Application for a non-material amendment following a grant of planning permission.

Construction of 16 dwellings, comprising 4no. 3bedroom townhouses, 3no. 4 bedroom accessible houses and 9no. 2 bedroom flats with associated parking (resubmission of 19/01690/CS3)

Reference number:	<input type="text" value="20/00357/CS3"/>
Date of decision	<input type="text" value="20/08/2020"/>

The provision of additional photovoltaic panels on the roofs of the apartments and houses.

Ground Floor Plan

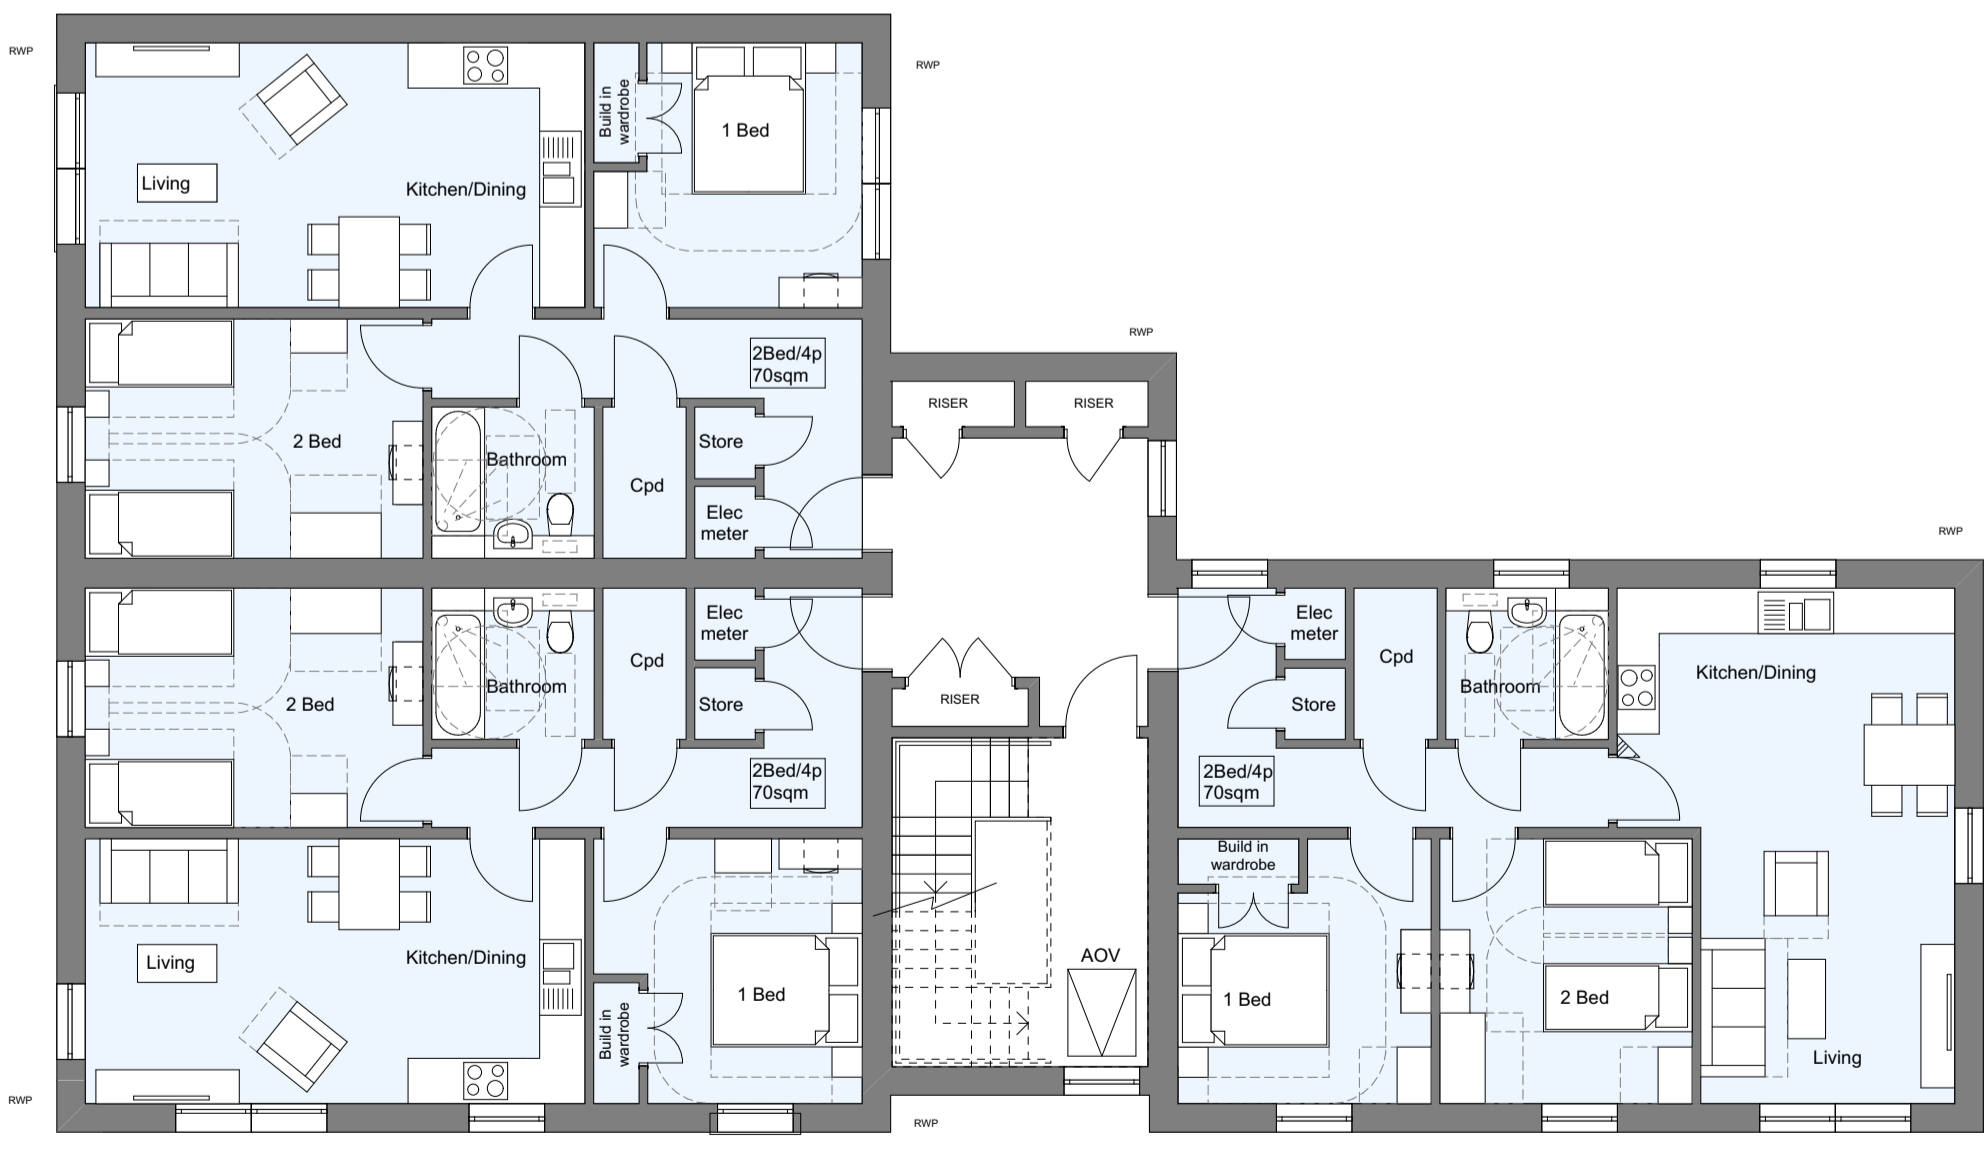
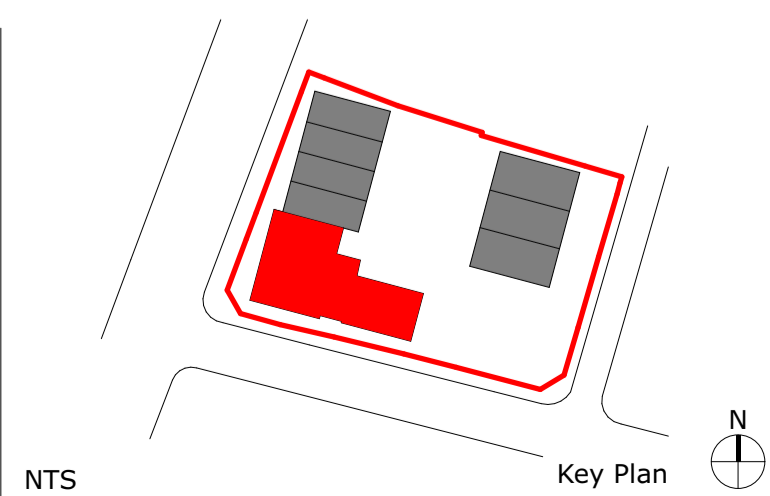
19.094.100 Rev E Proposed Site Plan (Roof Plan)  
19.094.202 Rev C Proposed Flats  
19.094.205 Rev C Street Scenes

19.094.100 Rev F Proposed Site Plan (Roof Plan)  
19.094.202 Rev D Proposed Flats  
19.094.205 Rev D Street Scenes

The amendment is being sought to improve the environmental performance, the efficiency and affordability of the units for the residents.
